**Byers Gill Solar  
EN010139**

# 3.3 DCO Schedule of Changes

Deadline 5 – November 2024

Revision 3

Drawing Title
Street Works, Public Rights of Way & Access Plans
 Sheet 11 of 13
APFP Regulation 5(2)(k)

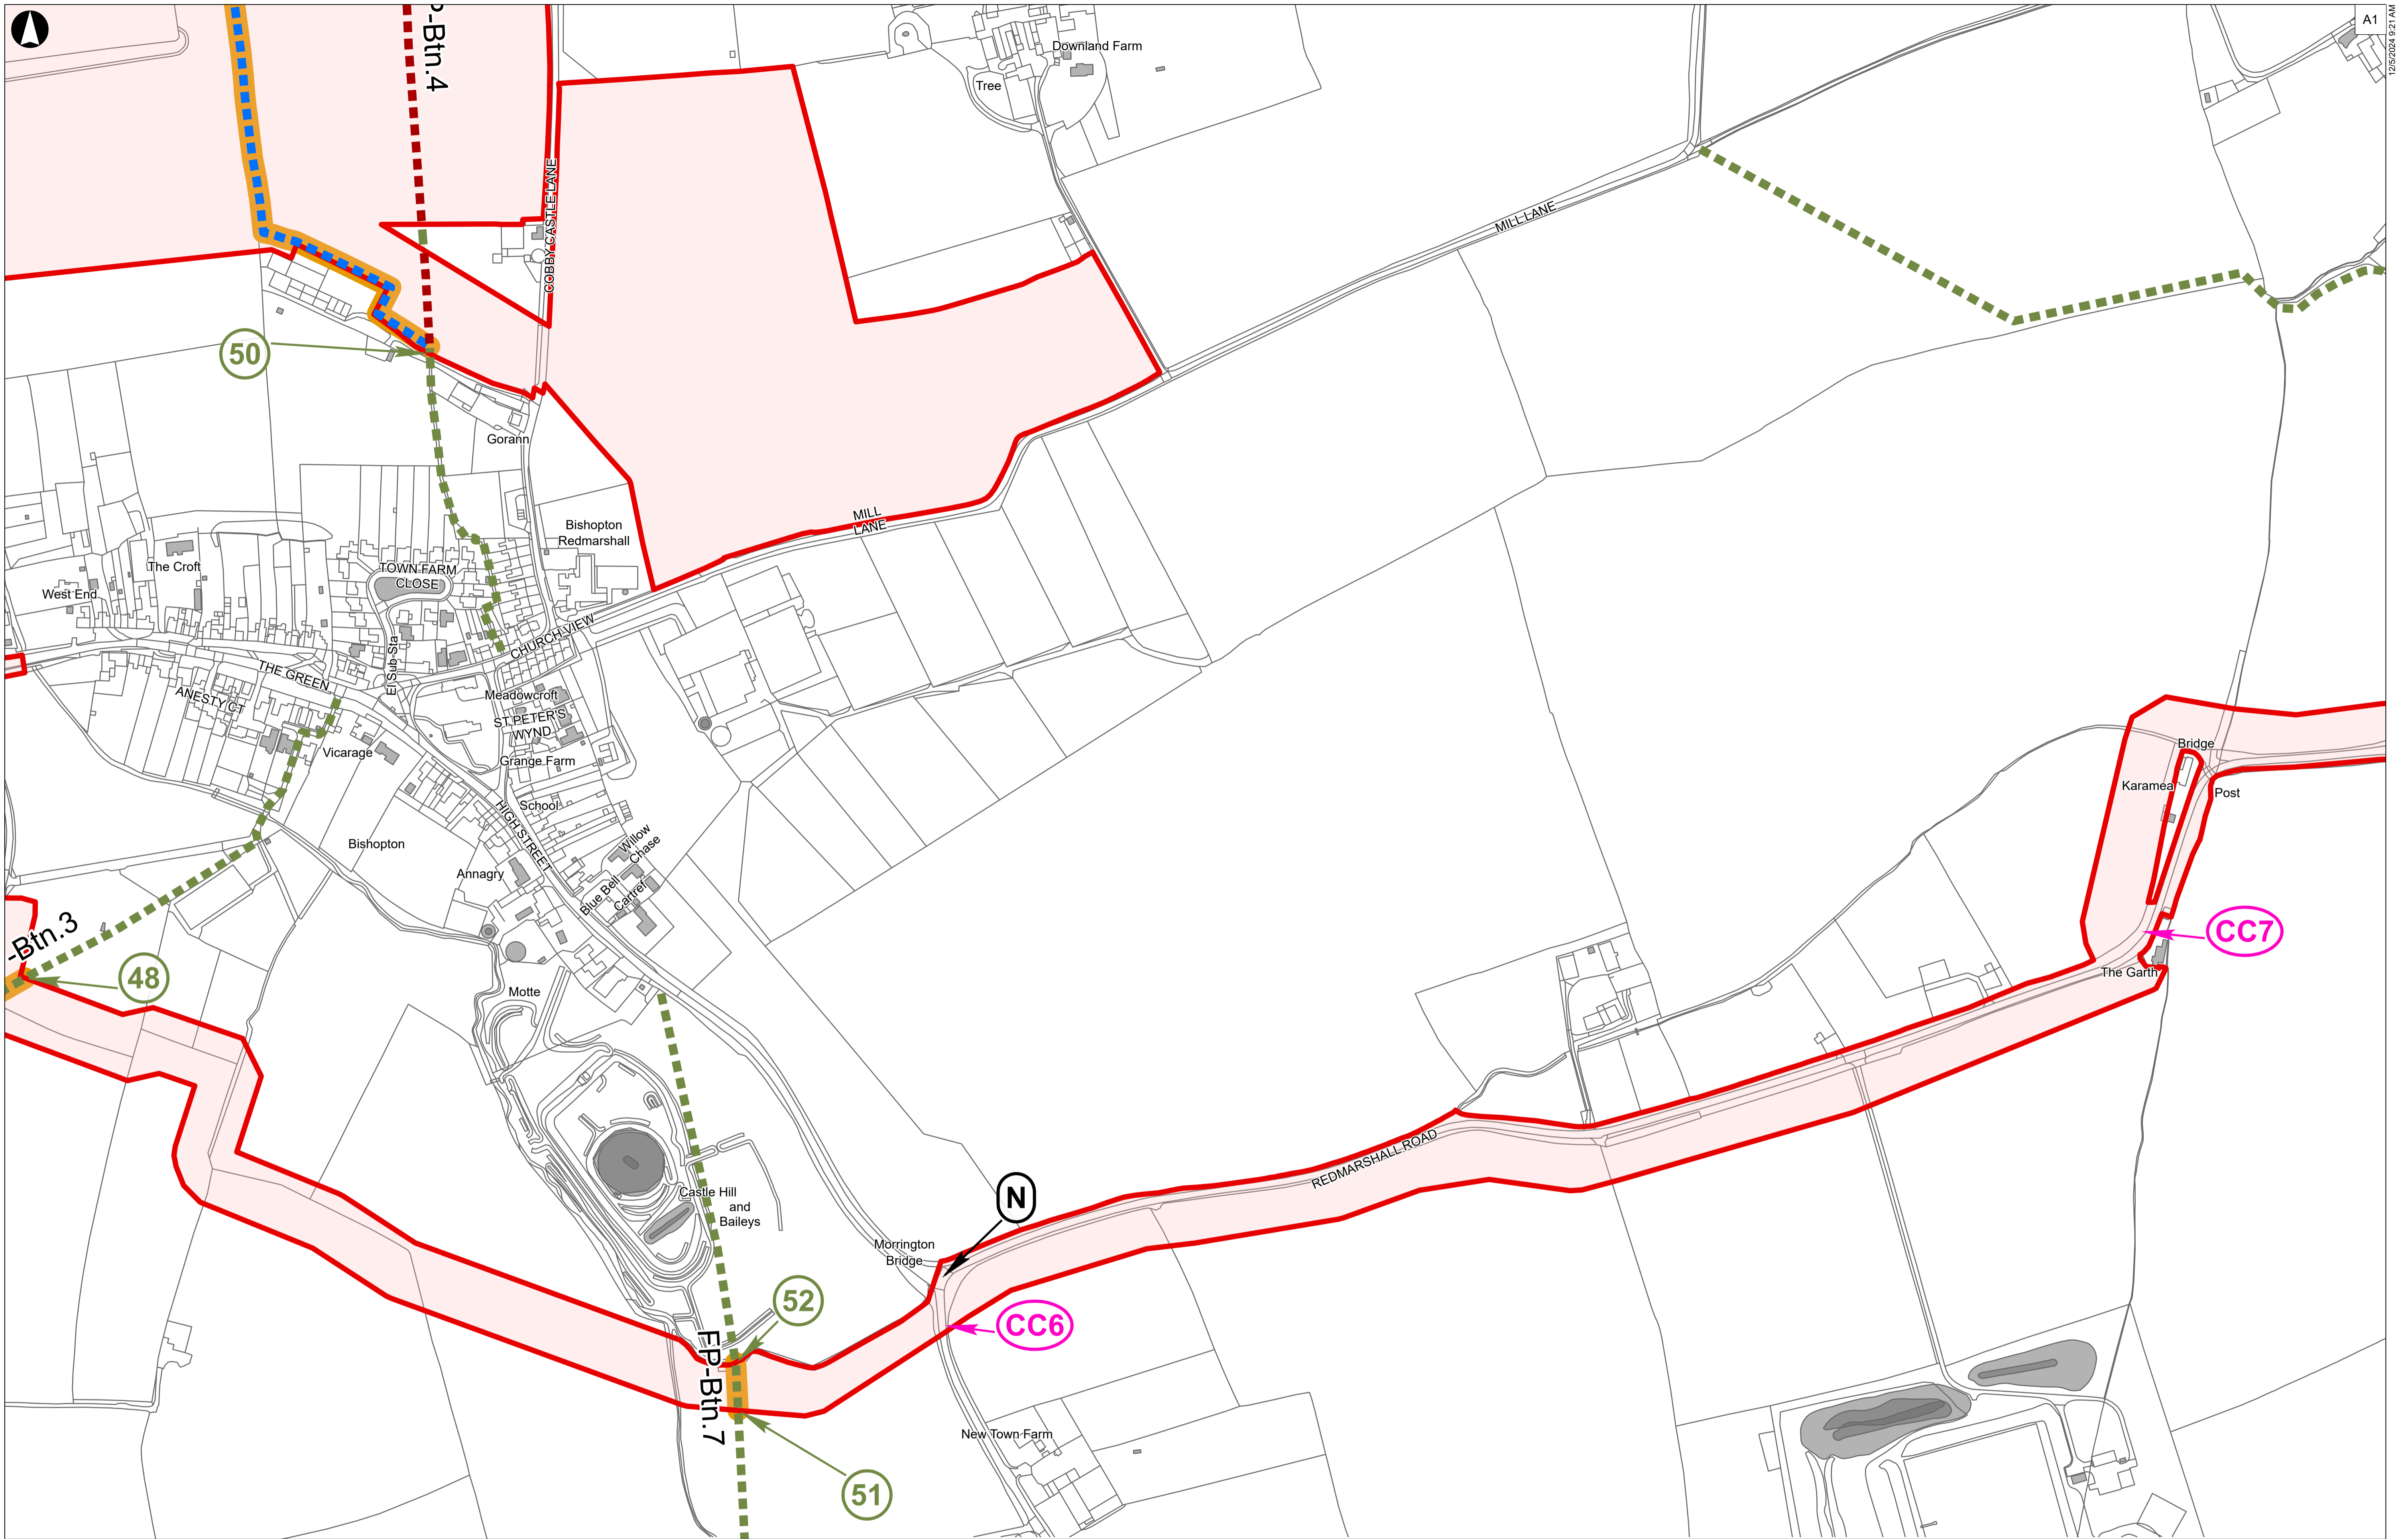
<p>Within the table of street works in Schedule 3, two rows have been added as follows:</p> <table border="1" data-bbox="577 802 1265 1310"> <tr> <td data-bbox="577 802 763 1054"><a href="#">Parish of Bishopton</a></td> <td data-bbox="763 802 913 1054"><a href="#">Folly Bank</a></td> <td data-bbox="913 802 1265 1054"><a href="#">Cable works beneath the width of street as shown with reference CC5 on sheet 9 of the street works, public rights of way and access plans.</a></td> </tr> <tr> <td data-bbox="577 1054 763 1310"><a href="#">Parish of Redmarshall</a></td> <td data-bbox="763 1054 913 1310"><a href="#">Redmarshall Road, in the vicinity of Morington Bridge</a></td> <td data-bbox="913 1054 1265 1310"><a href="#">Cable works beneath the width of street as shown with reference CC6 on sheet 11 of the street works, public rights of way and access plans.</a></td> </tr> </table>	<a href="#">Parish of Bishopton</a>	<a href="#">Folly Bank</a>	<a href="#">Cable works beneath the width of street as shown with reference CC5 on sheet 9 of the street works, public rights of way and access plans.</a>	<a href="#">Parish of Redmarshall</a>	<a href="#">Redmarshall Road, in the vicinity of Morington Bridge</a>	<a href="#">Cable works beneath the width of street as shown with reference CC6 on sheet 11 of the street works, public rights of way and access plans.</a>	<p>These two rows have been added to provide street works descriptions for two locations where the Applicant proposes to carry out cabling works across the width of a street for the purpose of delivering the off-road cable route. These descriptions are included as a correction to Revision 1 of the dDCO.</p> <p>Corresponding amendments have been made to the Street Works, Public Rights of Way and Access Plans to indicate these locations.</p>

<a href="#">Parish of Bishopton</a>	<a href="#">Folly Bank</a>	<a href="#">Cable works beneath the width of street as shown with reference CC5 on sheet 9 of the street works, public rights of way and access plans.</a>						
<a href="#">Parish of Redmarshall</a>	<a href="#">Redmarshall Road, in the vicinity of Morington Bridge</a>	<a href="#">Cable works beneath the width of street as shown with reference CC6 on sheet 11 of the street works, public rights of way and access plans.</a>
